RE: Timber Clad structure at Harefield Hospital - Ref: 9011/APP/2018/18541 message

Retention of hospital waste store (Retrospective Application) with new boundary hedge planting.

P Ground Floor Plan as Proposed
PL-003 SCALE: 1:50 @ A1

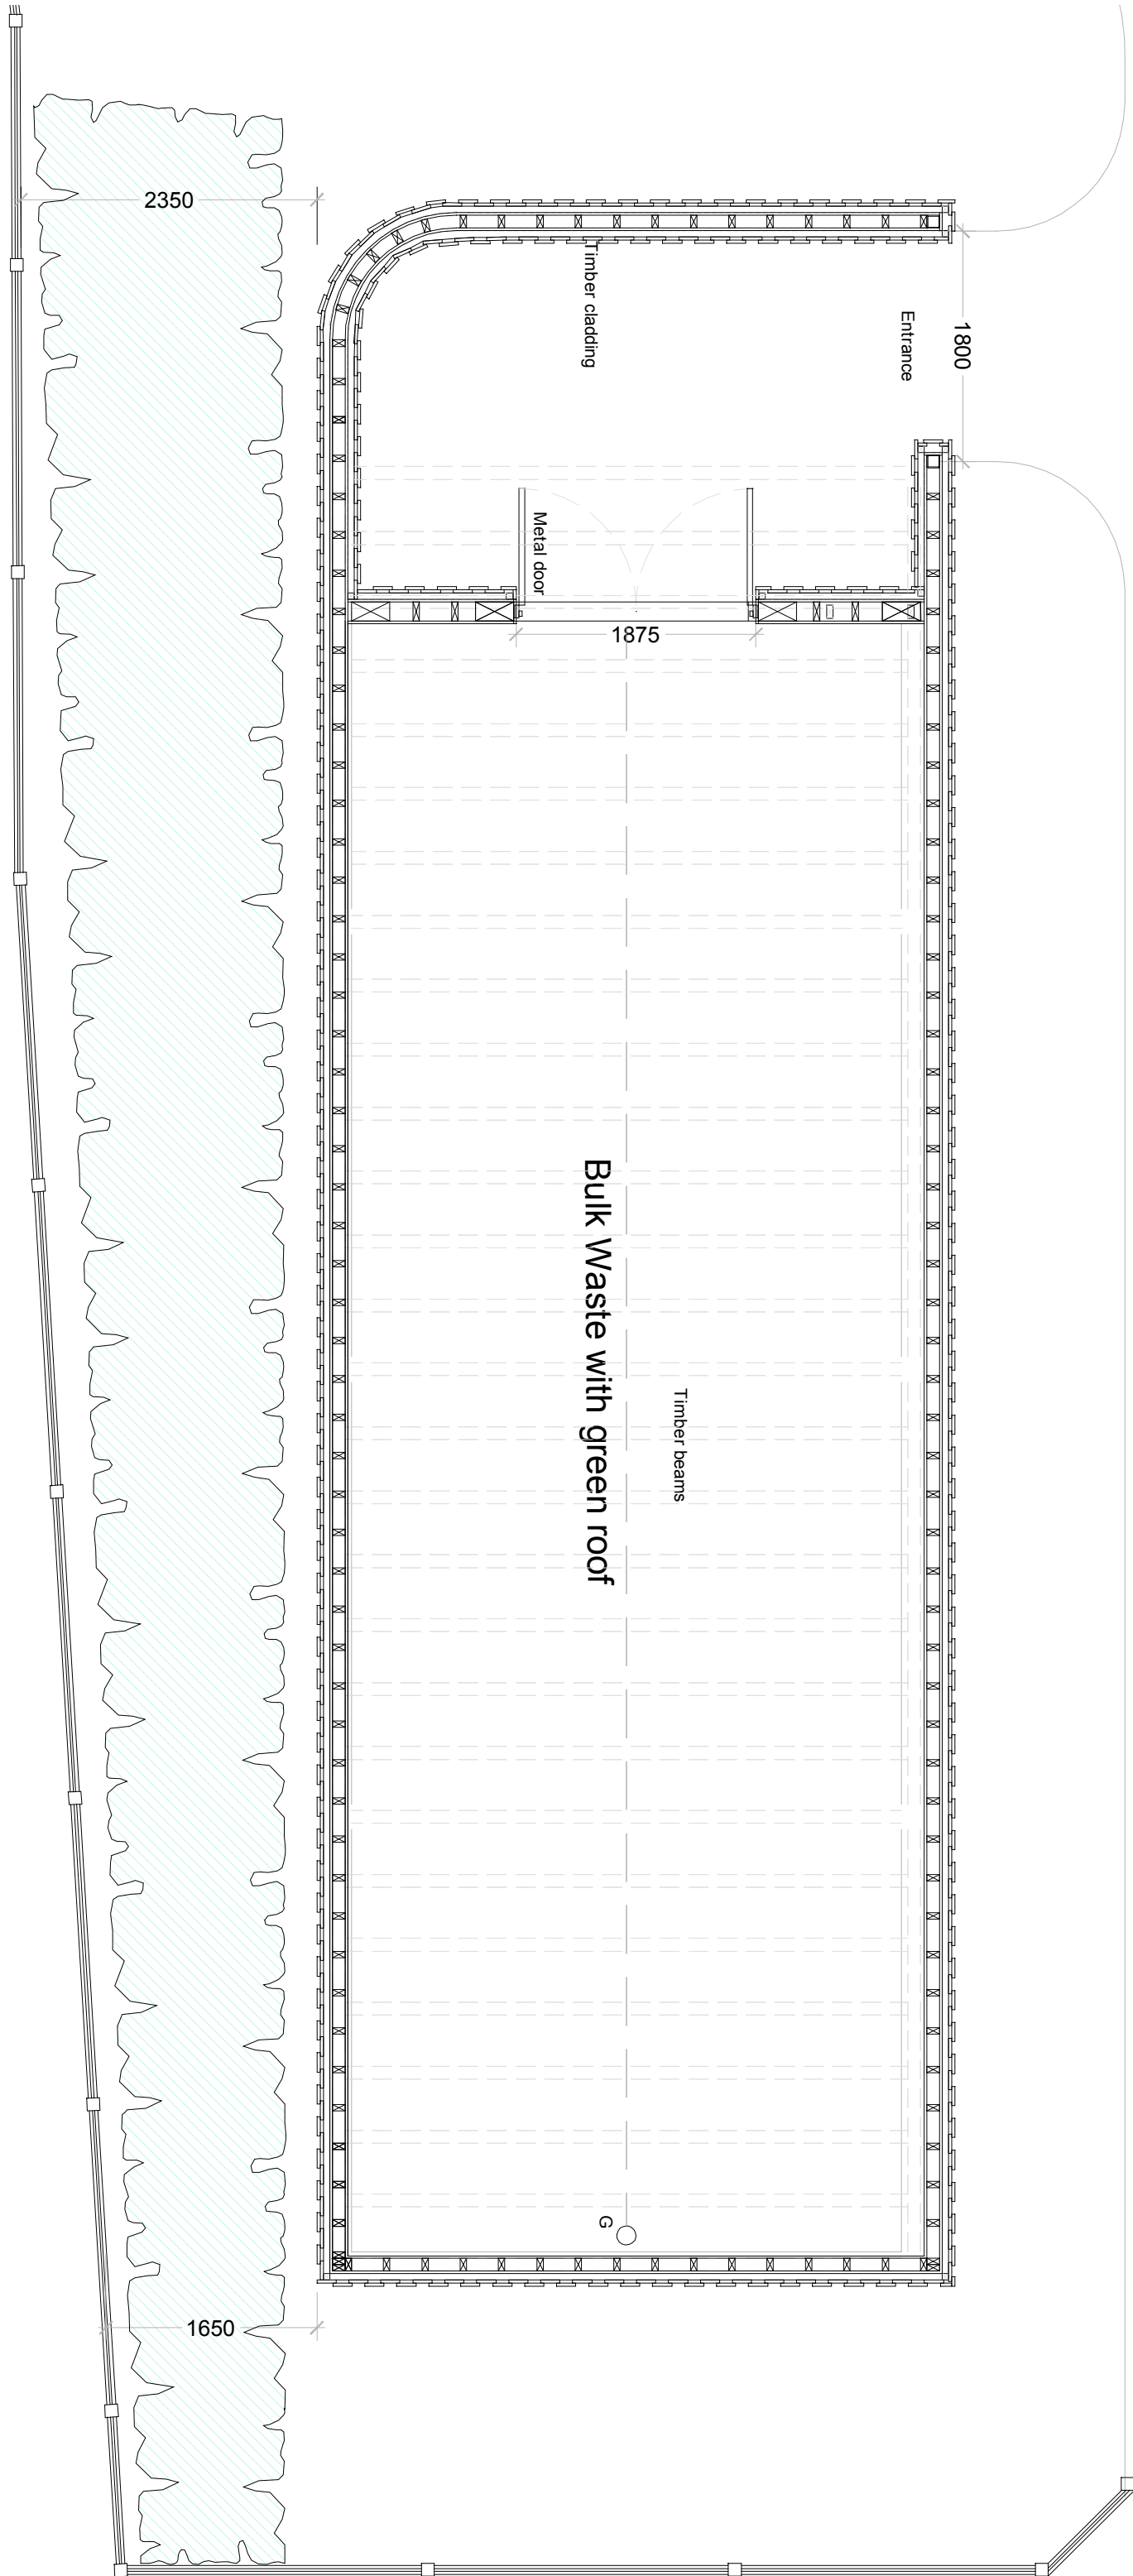
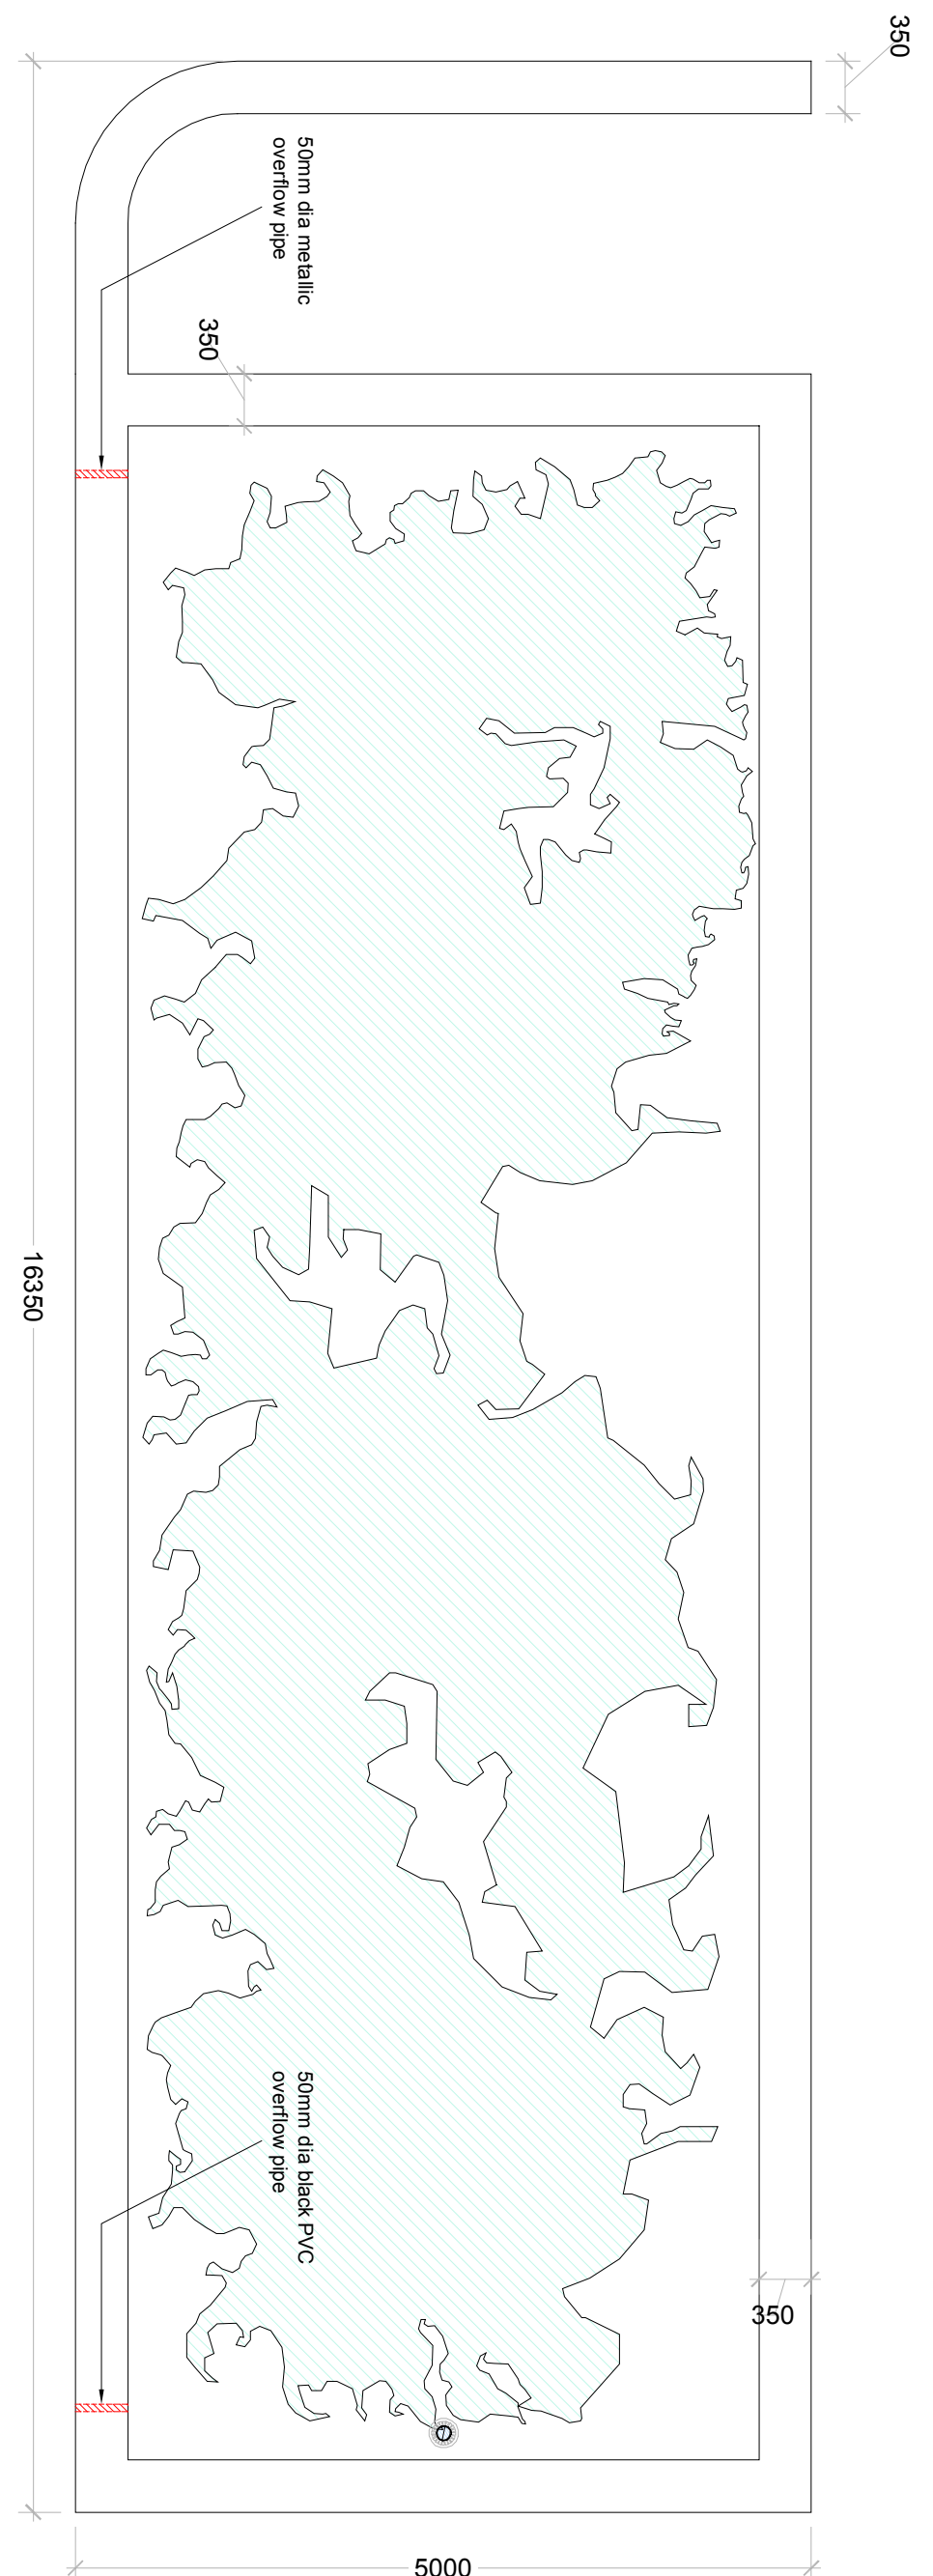
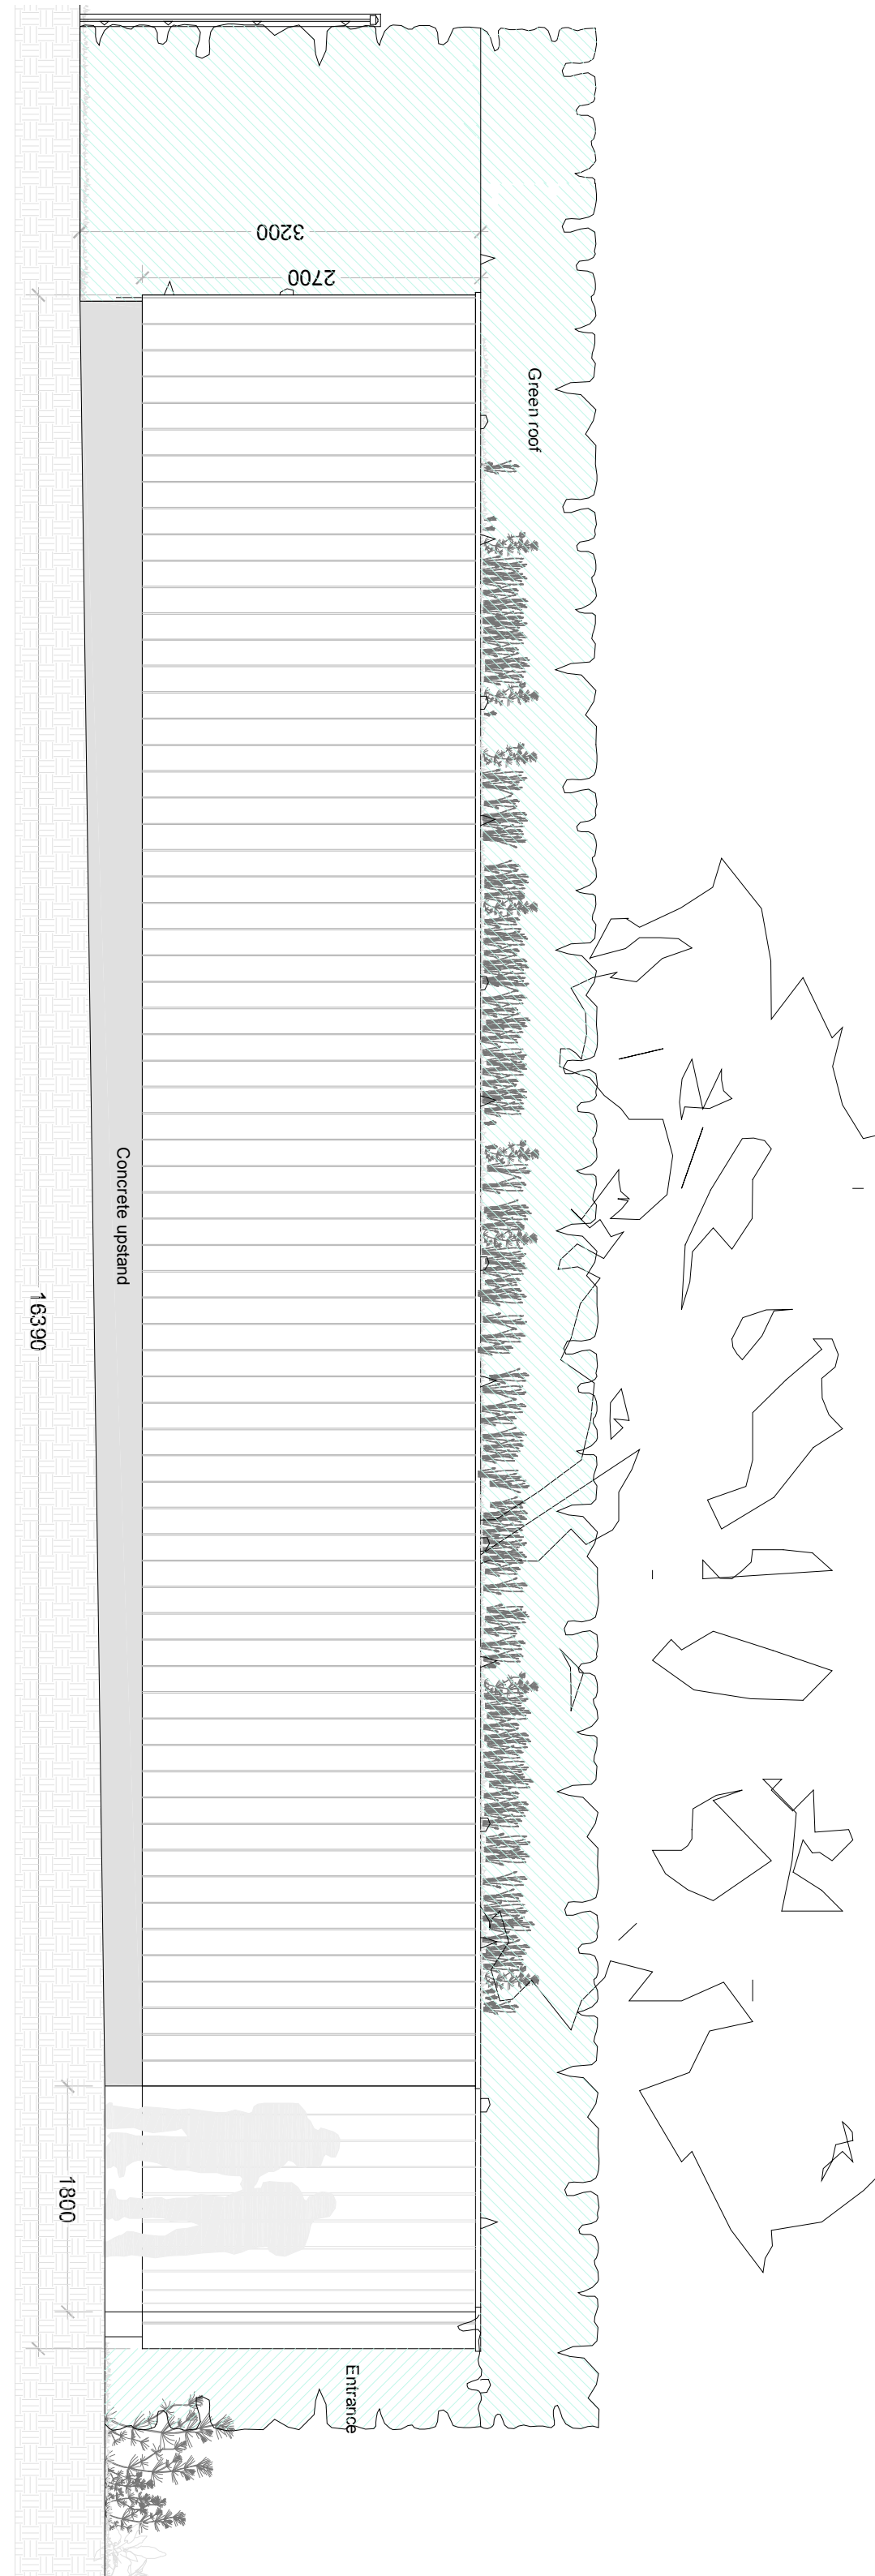
There is a side fence shown at the square end of the store on the floor/elevation plan which is not shown on the site plan, (described as 'Location Plan' - Drw. No. PL-002 refers) - can this be added - it will make things a little clearer.
